**WELWYN HATFIELD BOROUGH COUNCIL – DEVELOPMENT MANAGEMENT
DELEGATED REPORT**

APPLICATION No:	S6/2013/1705/FP
APPLICATION Site:	12 Daffodil Close, Hatfield

The application seeks planning permission for the installation of 4 rooflights and a centrally positioned dormer window to the front roof slope and 2 rooflights and 2 dormer windows to the rear roof slope. Neighbouring properties have loft conversions with rooflights and dormer windows to the front and rear roof slopes, although they differ in both style and size. The property also benefits from a double garage and hardstanding for 2 cars to the rear of the site.

DRAWING TITLE : EXISTING & PROPOSED
 FLOOR PLANS

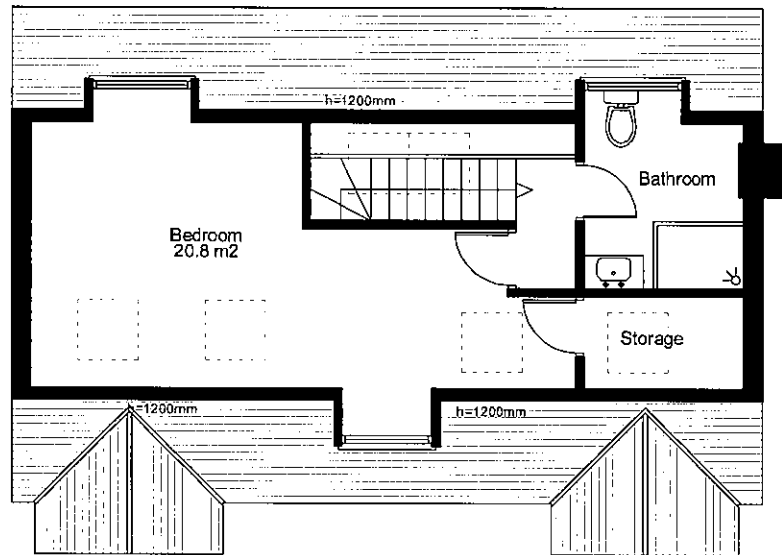
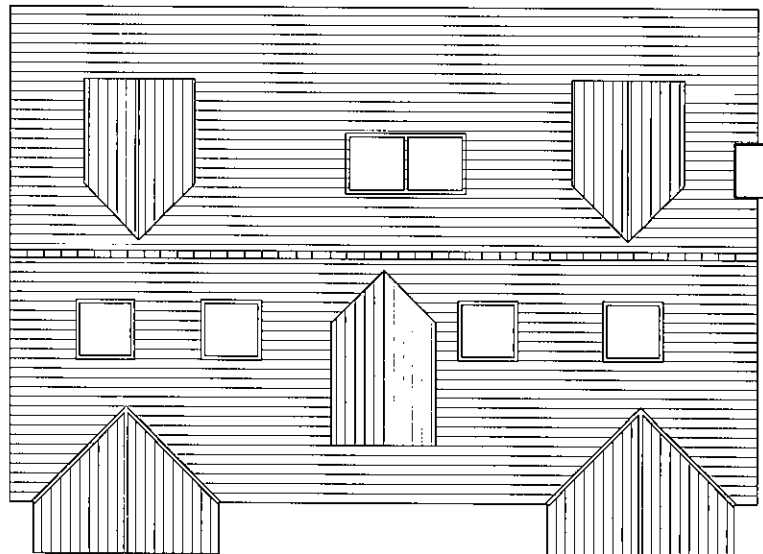
With regard to the front roof slope, it is proposed to install 4 rooflights of approximate dimensions of 0.8m by 0.8m and a centrally positioned dormer window. In addition the applicant also wishes to install a dormer window on the front roof slope which would measure approximately 1.4m wide, 2.1m high and be sited approximately 0.4m down from the ridge of the dwelling. Furthermore, the application also includes alterations to the rear roof slope. The applicant wishes to install 2 rooflights of approximate dimensions of 0.8m by 0.8m centrally in the roof in addition to 2 dormer windows measuring approximately 1.4m wide and 2.1m high on the rear roof slope.

From the submitted plans, the property would create one additional bedroom in the existing loft space. As existing, this 4 bedroom property currently has provision for 4

cars, 2 in the double garage and 2 on the hardstanding in front of the garage. An additional bedroom in this instance would not increase the parking provision for the resultant dwelling. The Local Planning Authority's requires that 3 spaces are provided for a 5 bedroom property of this size. Therefore even with the additional bedroom, there is currently sufficient provision onsite parking and as a result the application is in accordance with Policy M14 and the parking standards in the supplementary planning guidance.

DRAWING TITLE : PROPOSED ELEVATIONS  
ELEVATIONS

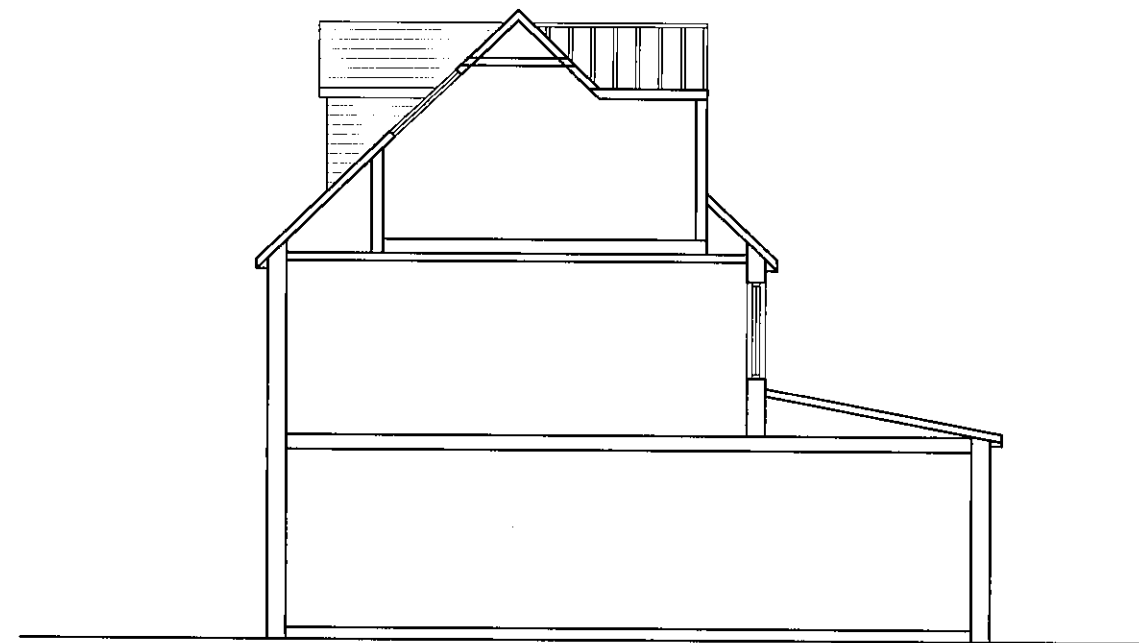
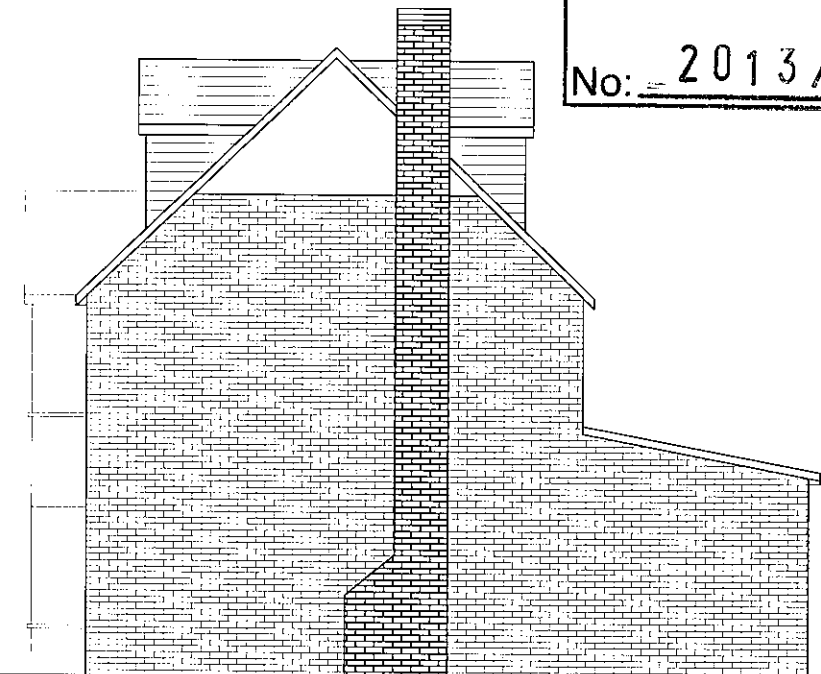
These 2 dormer windows would also be sited approximately 0.4m down from the existing ridge. Their presence would increase the bulk of the roof somewhat however this positioning would make them appear appropriately subordinate to the host dwelling and not a prominent feature on the roof slope.

All 3 dormer windows would have pitched roofs with hanging tiles on the vertical faces. The materials proposed for the dormer windows would match that of the existing bay windows to the front and the hipped section of roof serving the second storey form. Therefore these elements of the application are considered to be complementary to the existing design. Furthermore, it is considered that both roof slopes would continue to appear uncluttered due to their sufficient size and the proposed even distribution of the dormer windows and rooflights.

All the proposed rooflights would match the appearance the modestly sized rooflight installed on the front elevation of the dwelling at No.2 Daffodil Close. This neighbouring property also has 2 dormer windows to the front. A number of the neighbouring properties also have this roof form. The resultant dwelling would then not detract from the existing character of the area as the appearance of the additions would be in keeping with the immediate surrounding area.

3. C.5.2 3. The brickwork, tiling, bond, mortar, detailing, guttering, soffits and other external decorations of the approved roof alterations shall match the existing dwelling, unless otherwise approved in writing by the Local Planning Authority.
